PLANNING DEPARTMENT – Development Review Services

August 28, 2015

**RE: Advanced Auto Parts
Grading and Drainage Plan
Engineer's Stamp Date 8-17-2015 (File: H14D041)**

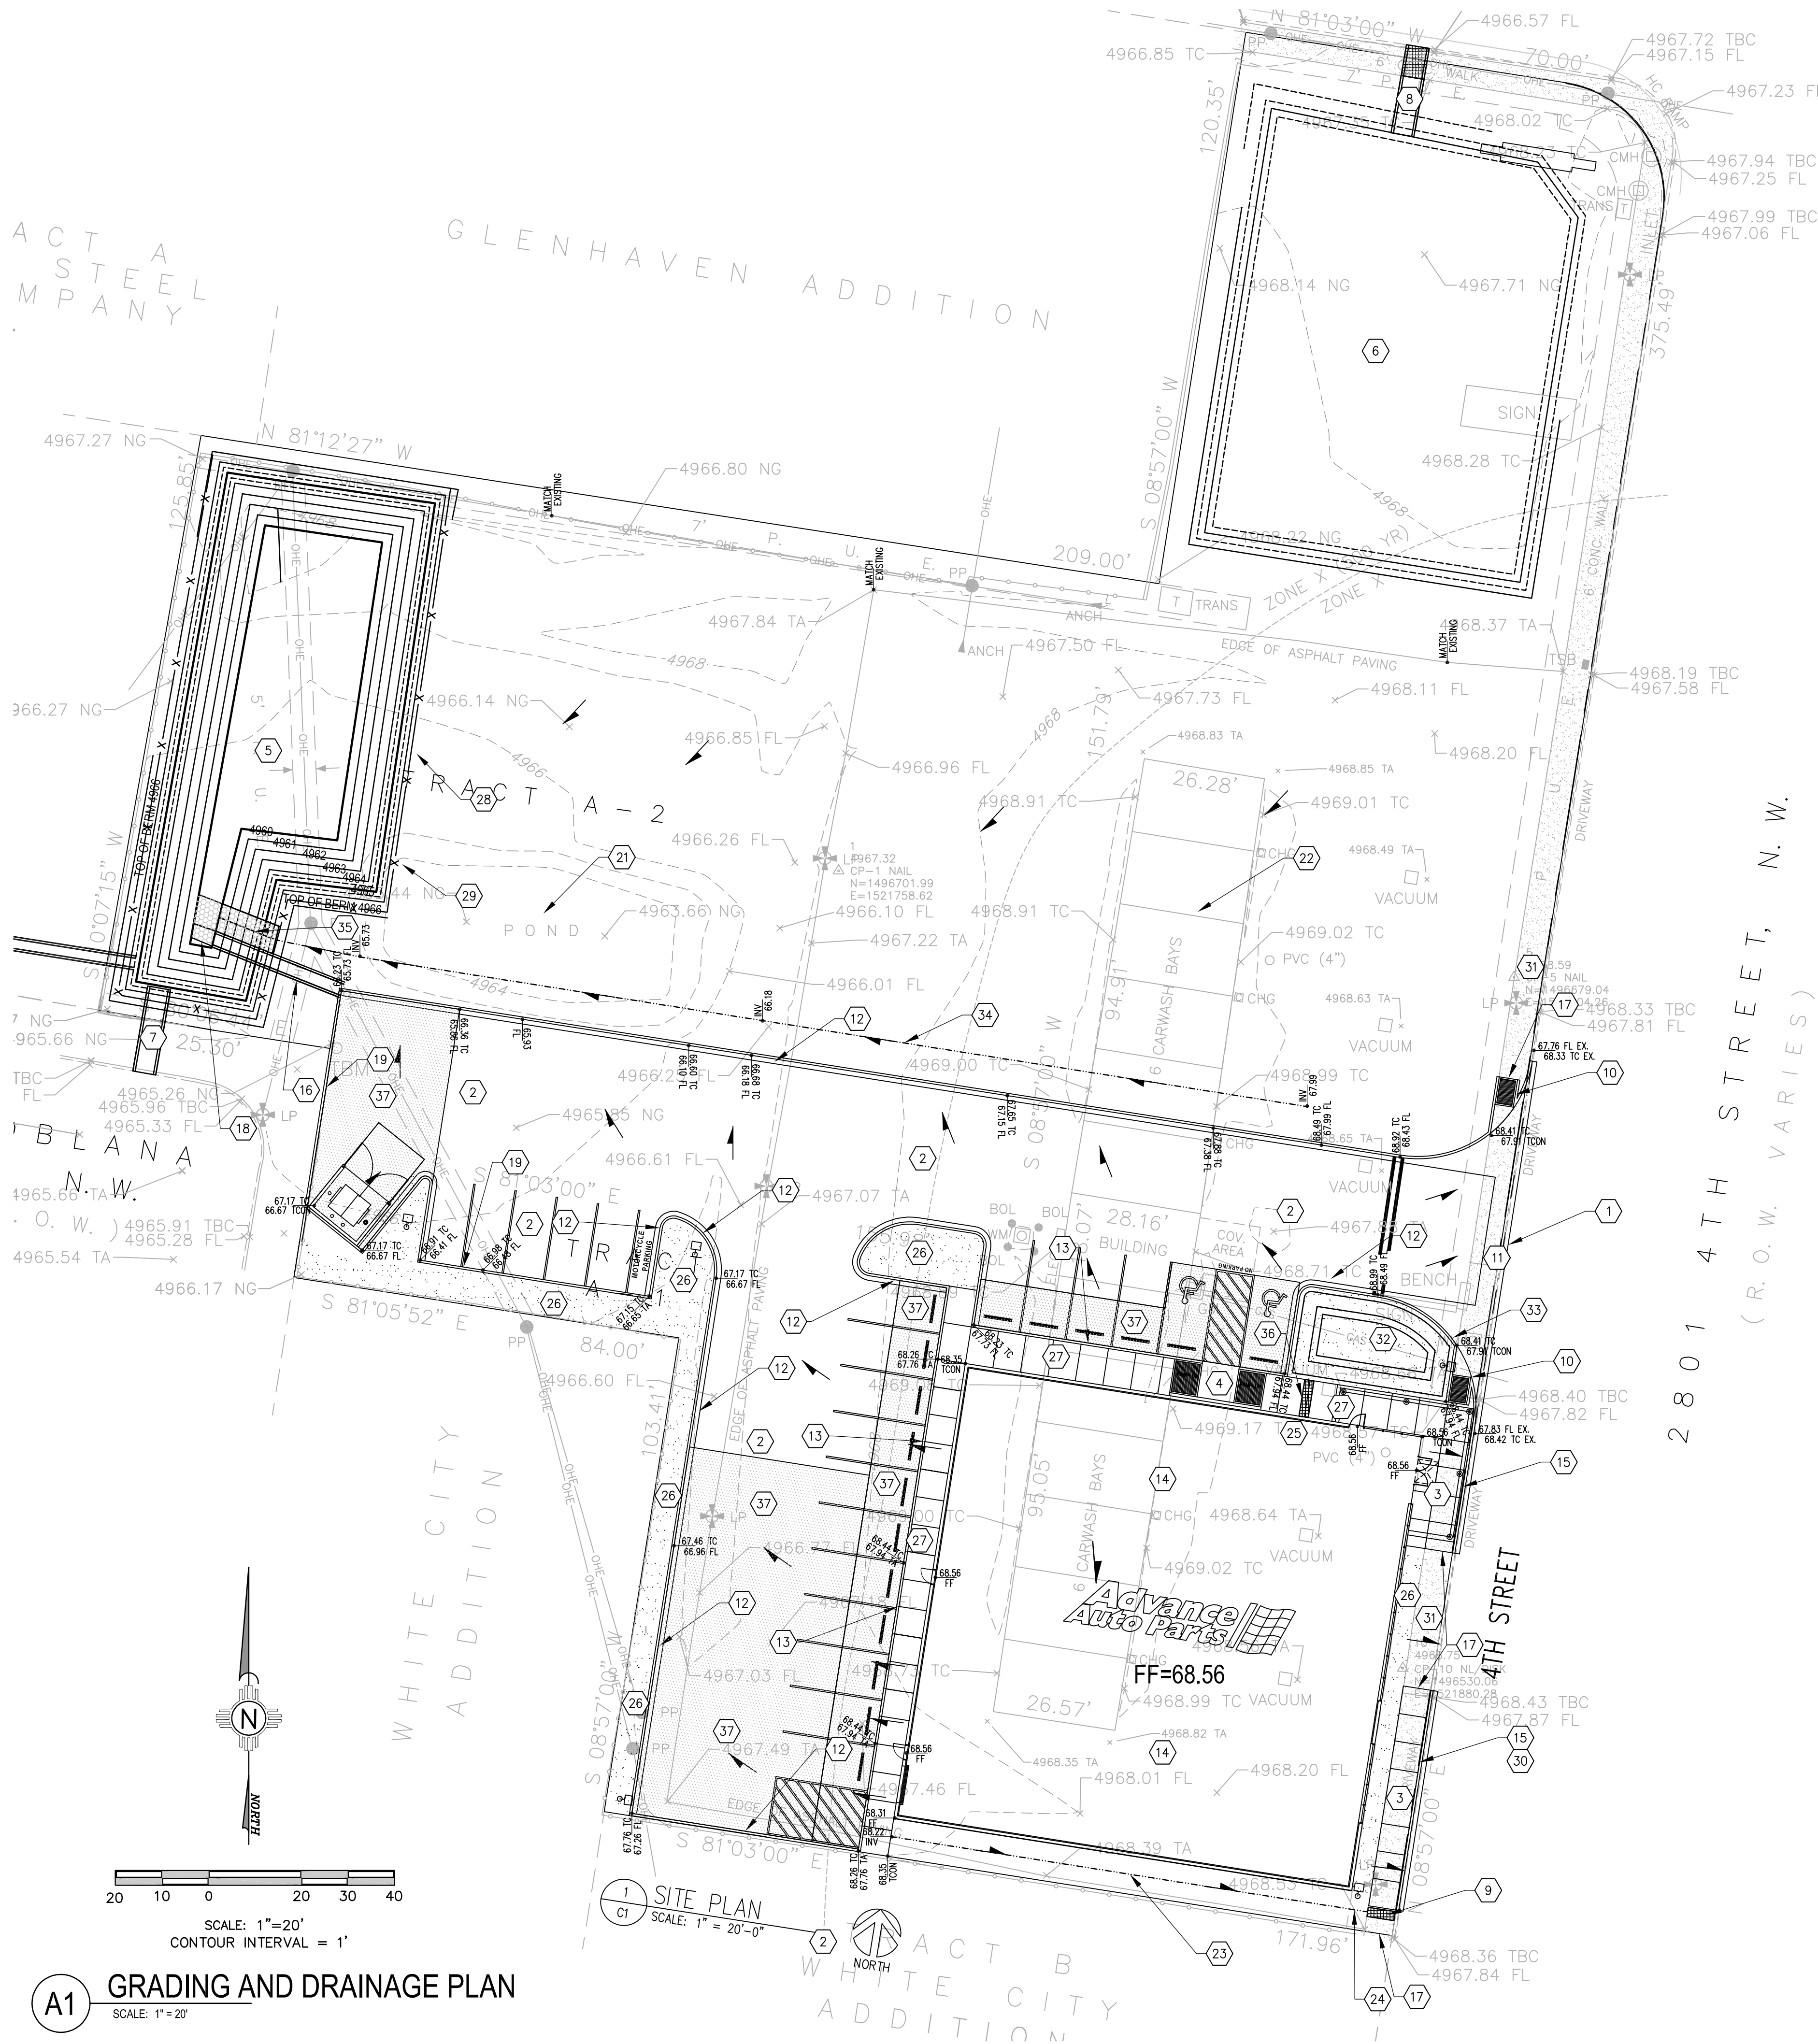
- a. Grading and Drainage plan with supporting calculation for the **Final Developed condition**. Dwg. C-102 is essentially this Final Condition Plan. However, the following needs to be corrected:

- i. Remove the Curb and Gutter separating the two properties, and show only the intended final condition.
 - ii. Show intended elevations/contours in the future parting lot

- iii. How will flows be directed to the pond in the final condition without the curb and gutter?
 - iv. Show the intended roof discharge points and direction of the future building

- v. Since full Retention ponds must retain the 100yr-10day volume, with 1 ft. of freeboard, Pond #1 is undersized.
 - vi. Future Pond #2 should be a detention pond, only retaining the First Flush and then discharging at a rate of 2.75cfs/Ac. The discharge mechanism will need to be designed.

- i. The Curb and Gutter that separates the phases (in i. above)
 - ii. How will the remaining site be graded in the interim? How and where will it discharge to?

3. For both Ponds: Show contour labels, Bottom of Pond elevation, Max WSEL, Provided Volume and Required Volume. (Show this on both the Interim and Future G&D plans, as it may be different)

4. Roof flows from the Advance Auto Parts must be directed to a first flush pond before discharging to swale along the south boundary. Perhaps the hatched area (handicap ramp?) at SW corner of the building can be used as such.

5. Provide calculations that size the SW culvert(s), the concrete swale. What is the WSEL?
6. Keyed notes should refer to the Detail on the Sheet C-501 (ie. See Detail D4 on Sht C-501)

7. Pond #2 has a 2:1 slope. More than a 3:1 slope required slope stabilization measures. Large cobbles are typically used.
